Ribble Valley Borough Council
By email

Your ref 3/2025/0801
Our ref DC/25/3013v4
Date 17-JUL-26

Location: Land to east of Salesbury View Wilpshire

Proposal: proposed erection of new residential development comprising 80 new homes, including 30% affordable housing, open space and associated infrastructure

Drawing Title
**DRAINAGE LAYOUT
SHEET 1**

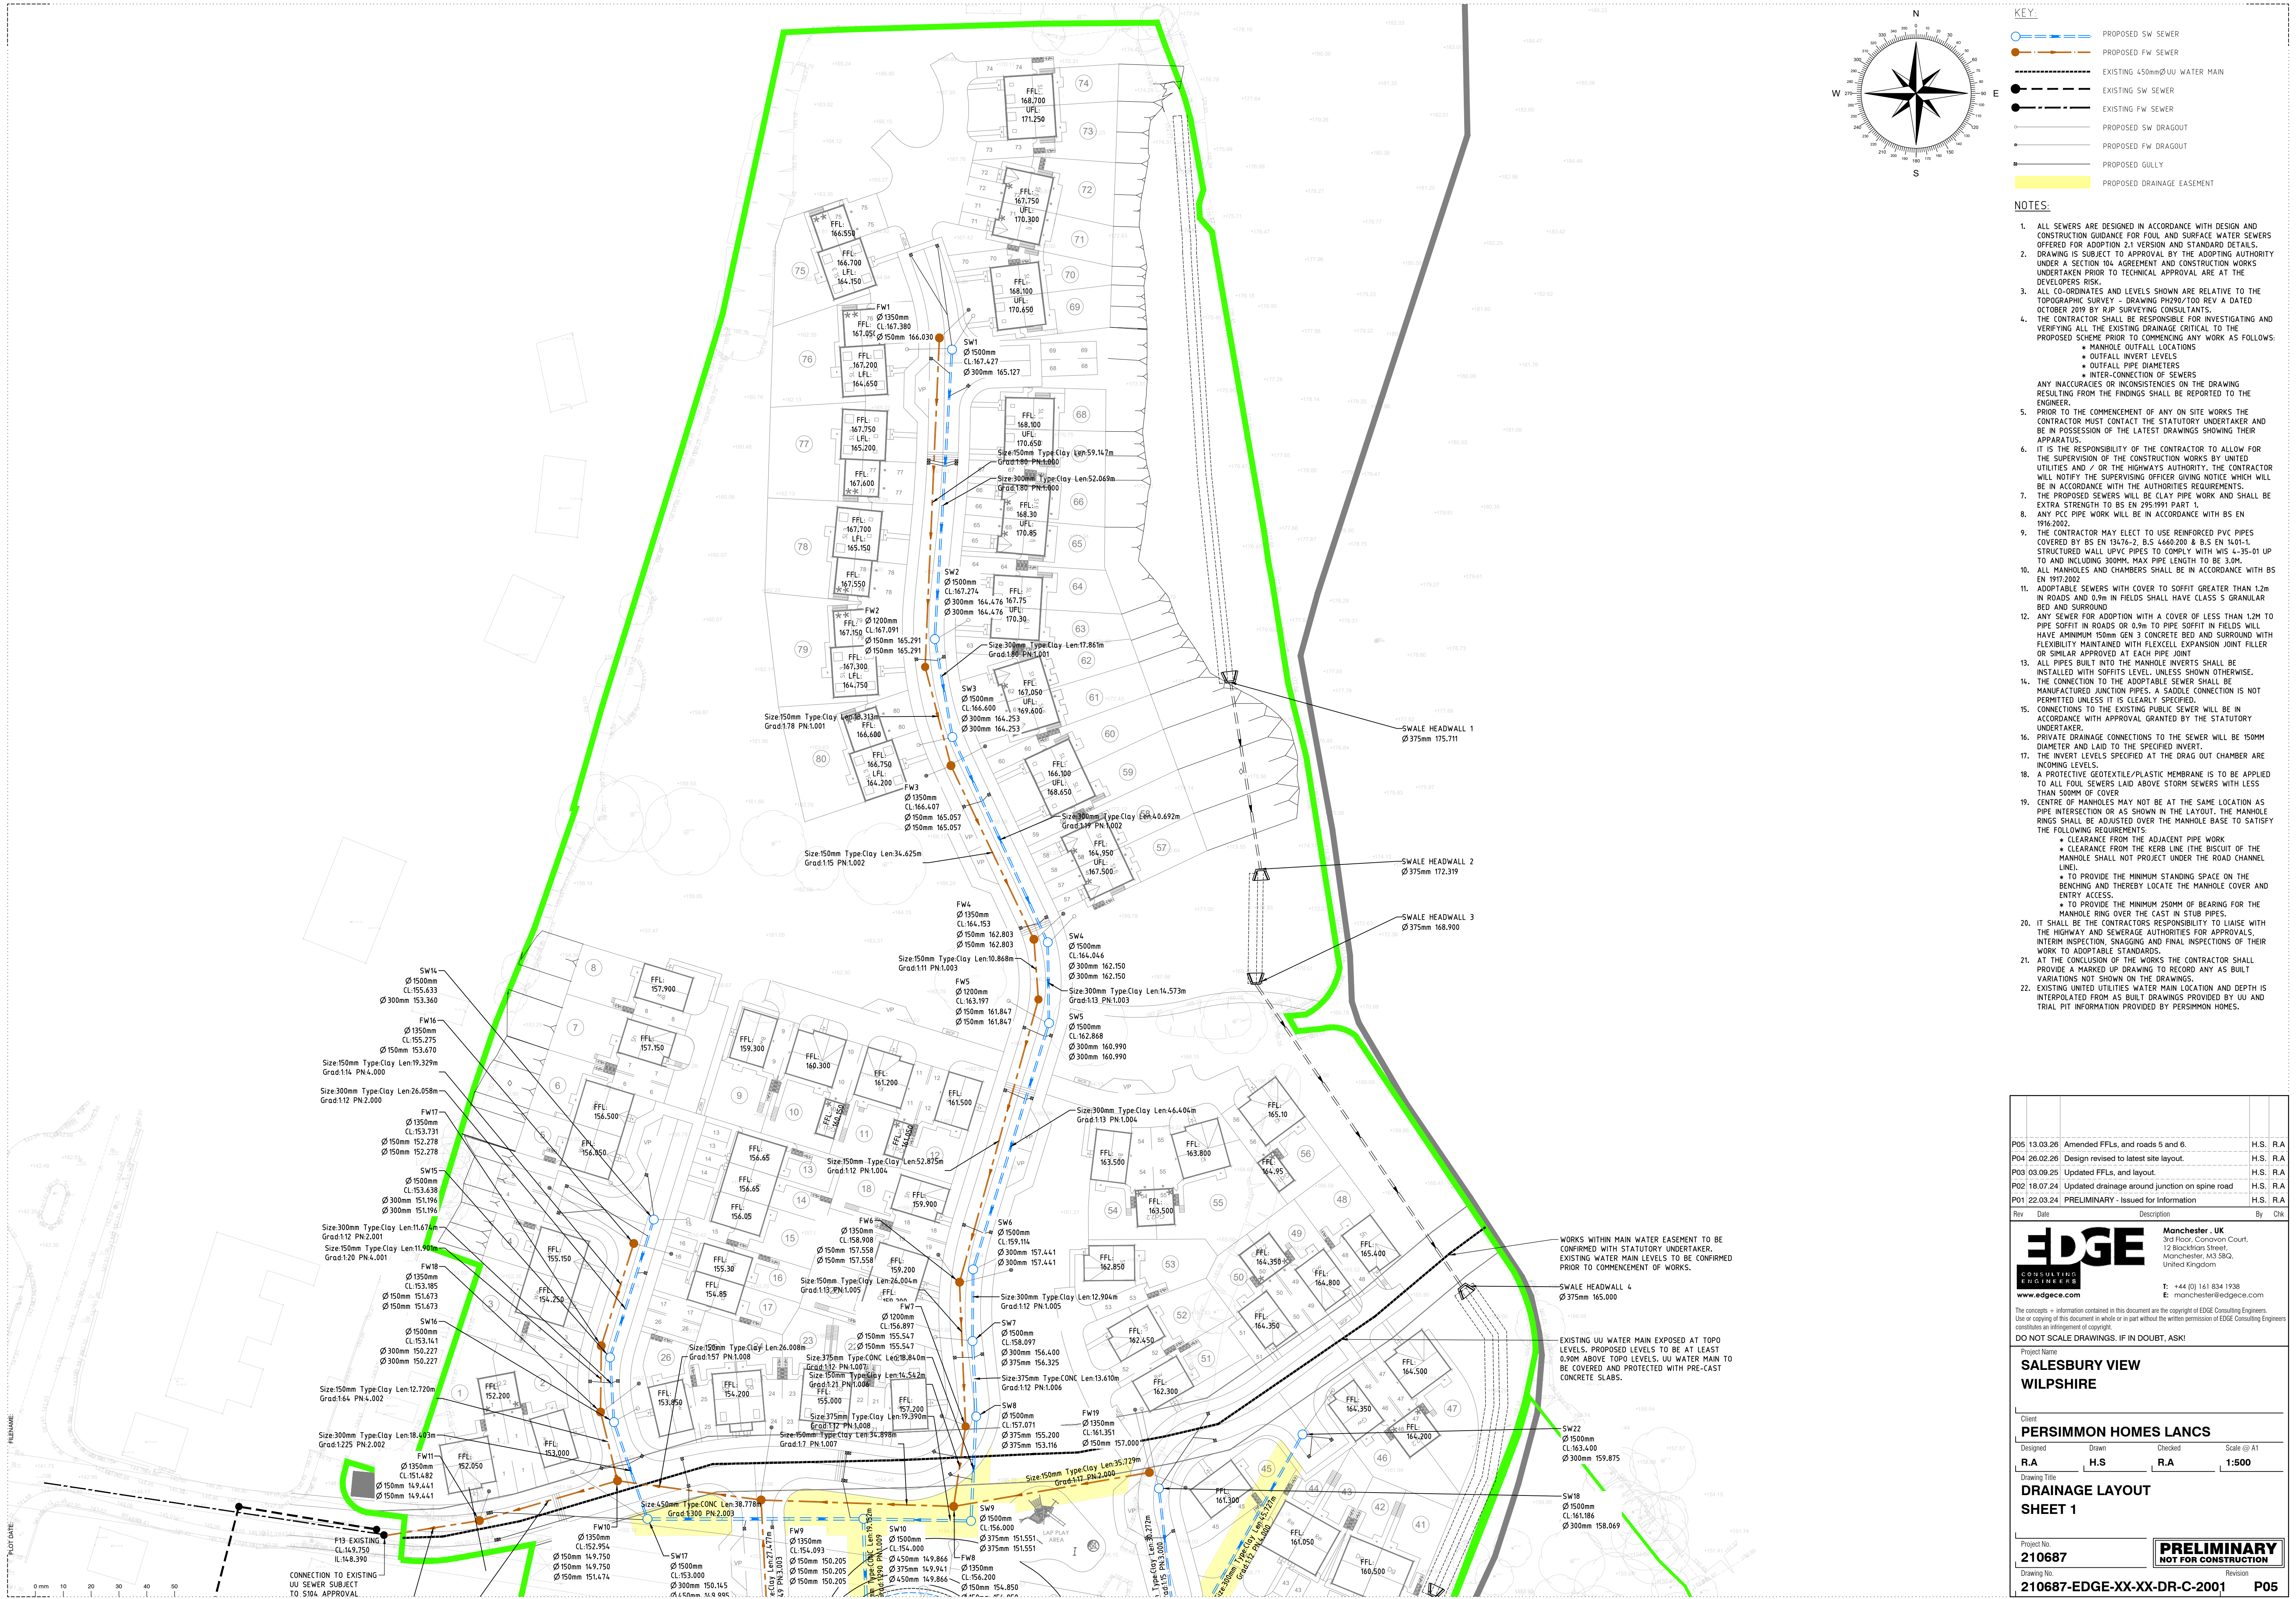
- Several manholes are situated within the easement of the water main which crosses the site, including FW10, FW11, SW11, SW 16 and SW17. These need to be moved outside of the easement.

Project No. 210687	PRELIMINARY NOT FOR CONSTRUCTION
Drawing No. 210687-EDGE-XX-XX-DR-C-1002	
	Revision P03

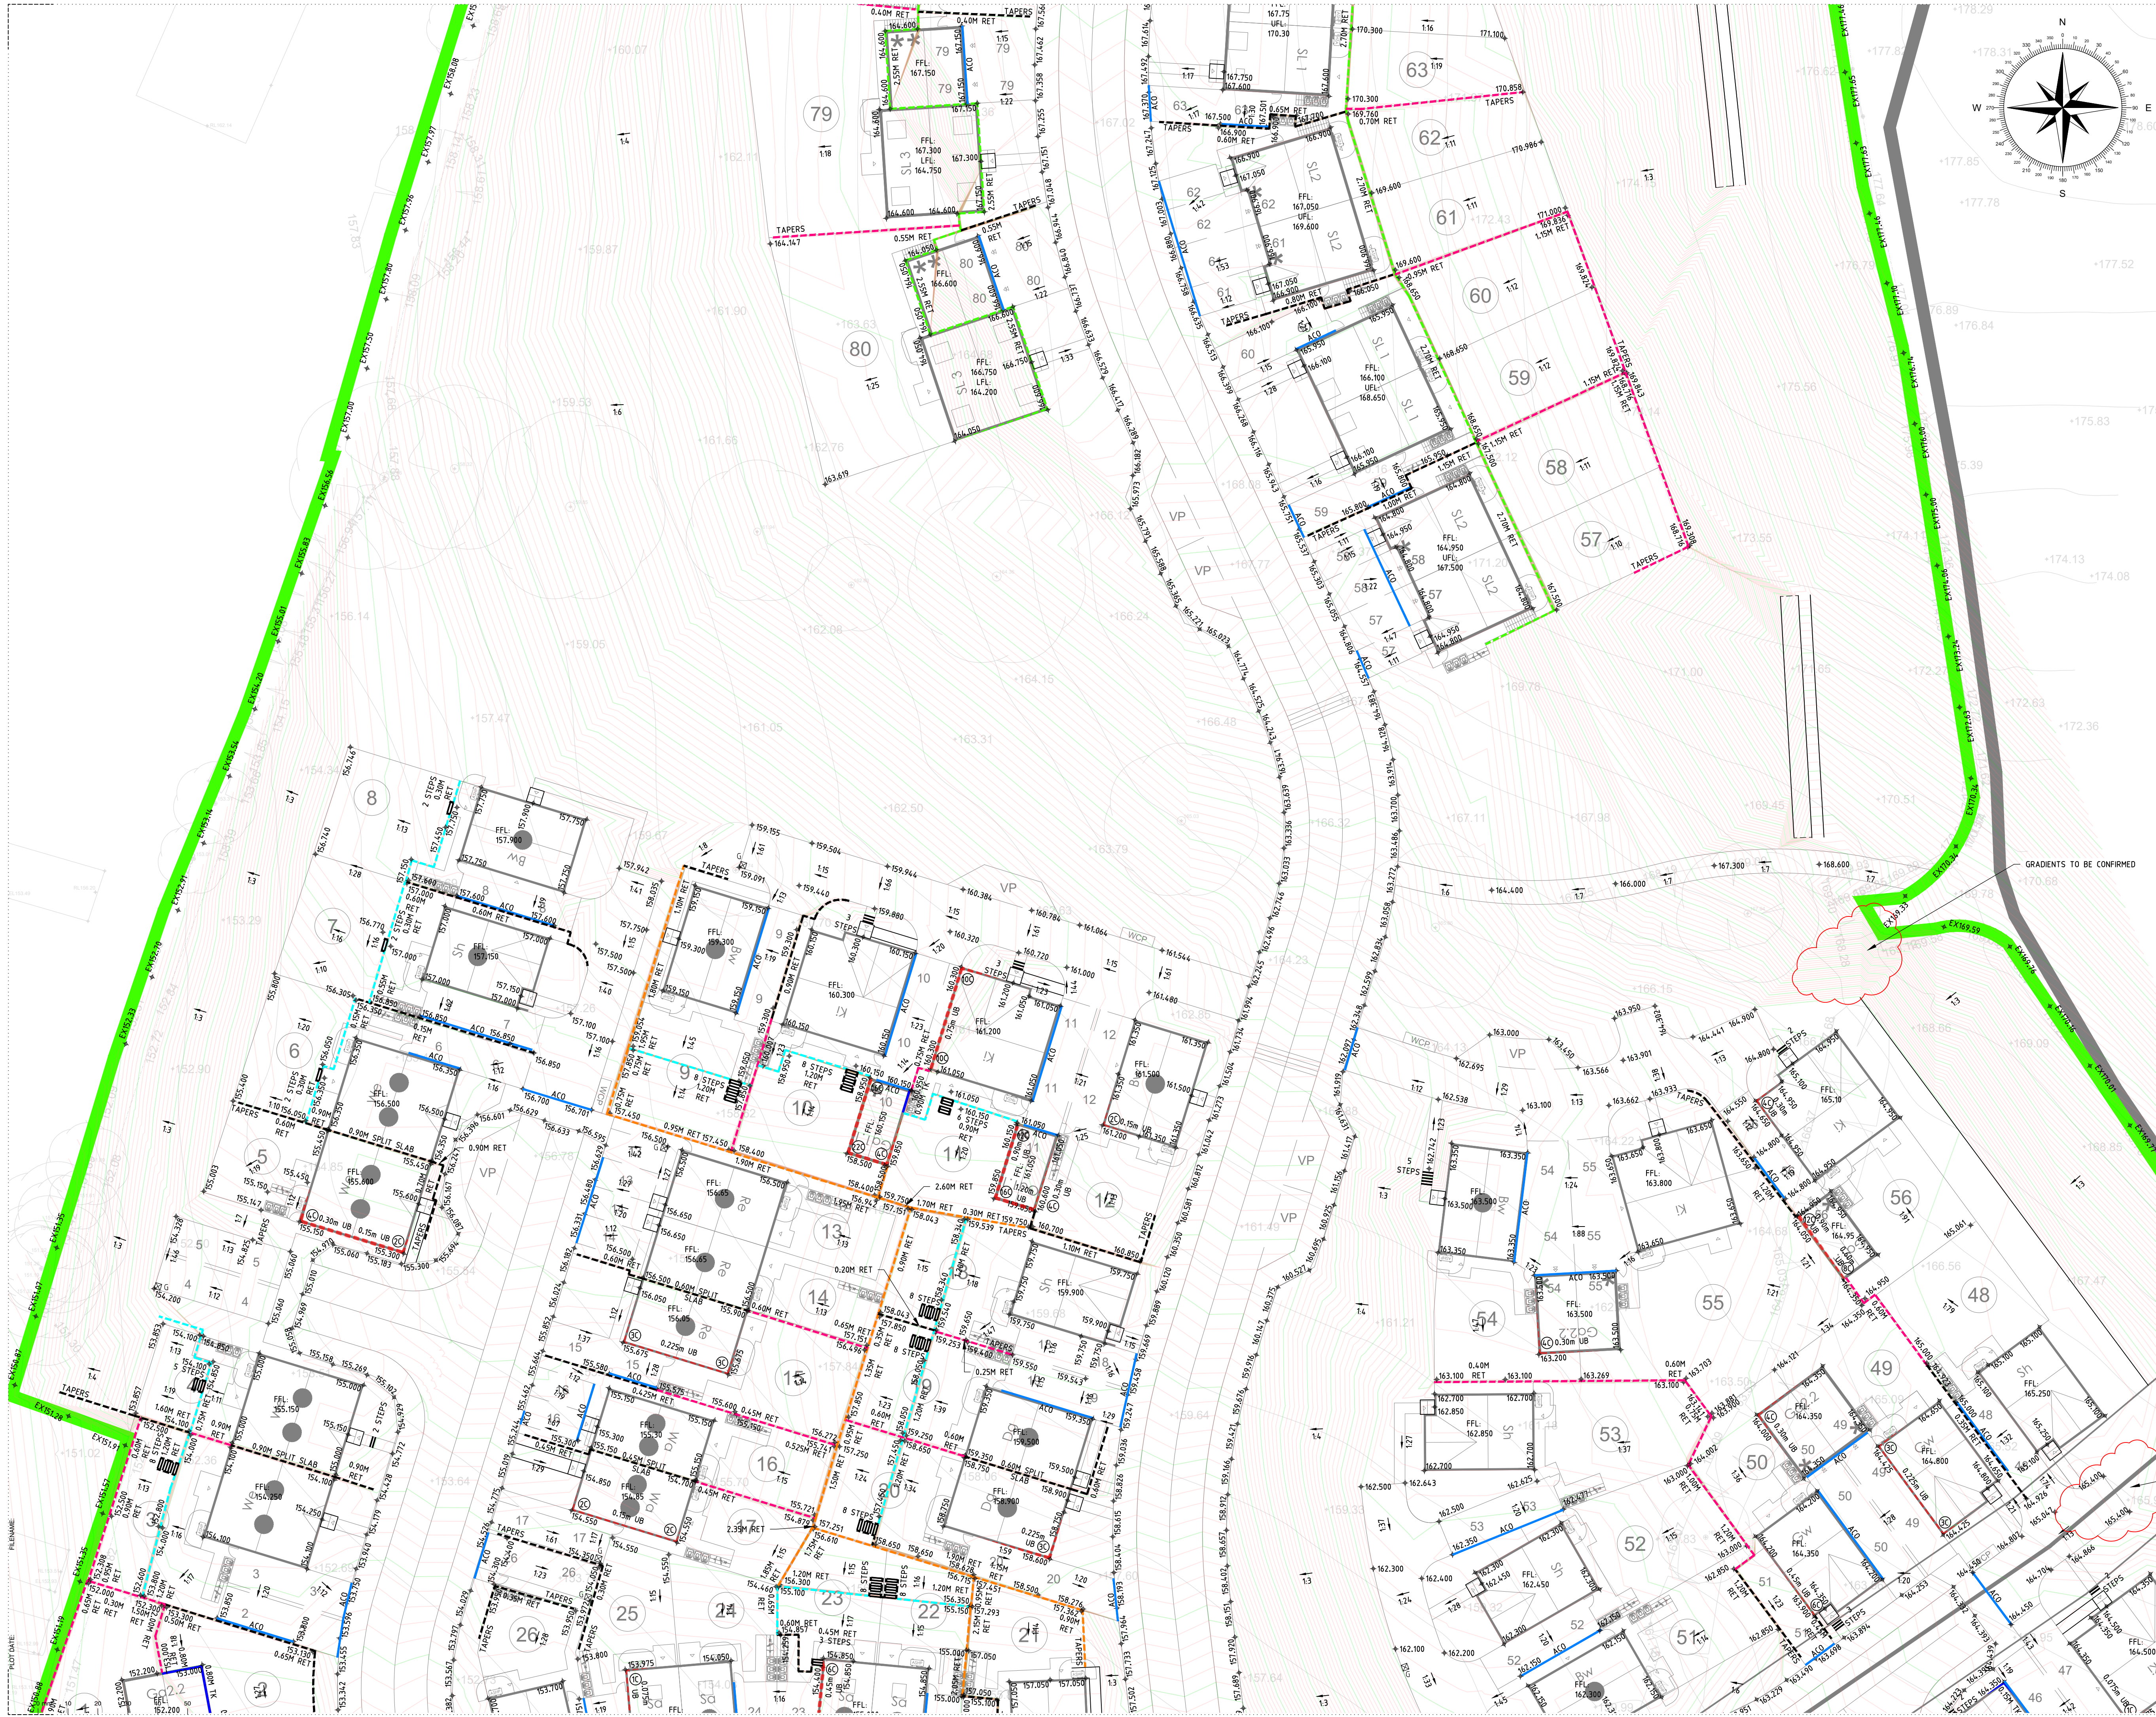
- No information has been provided regarding the steps which appear to be within the easement
- There is also no information with regards to how the main is to be protected during the construction works such as temporary main crossing points for construction plant and physical segregation of the easement.
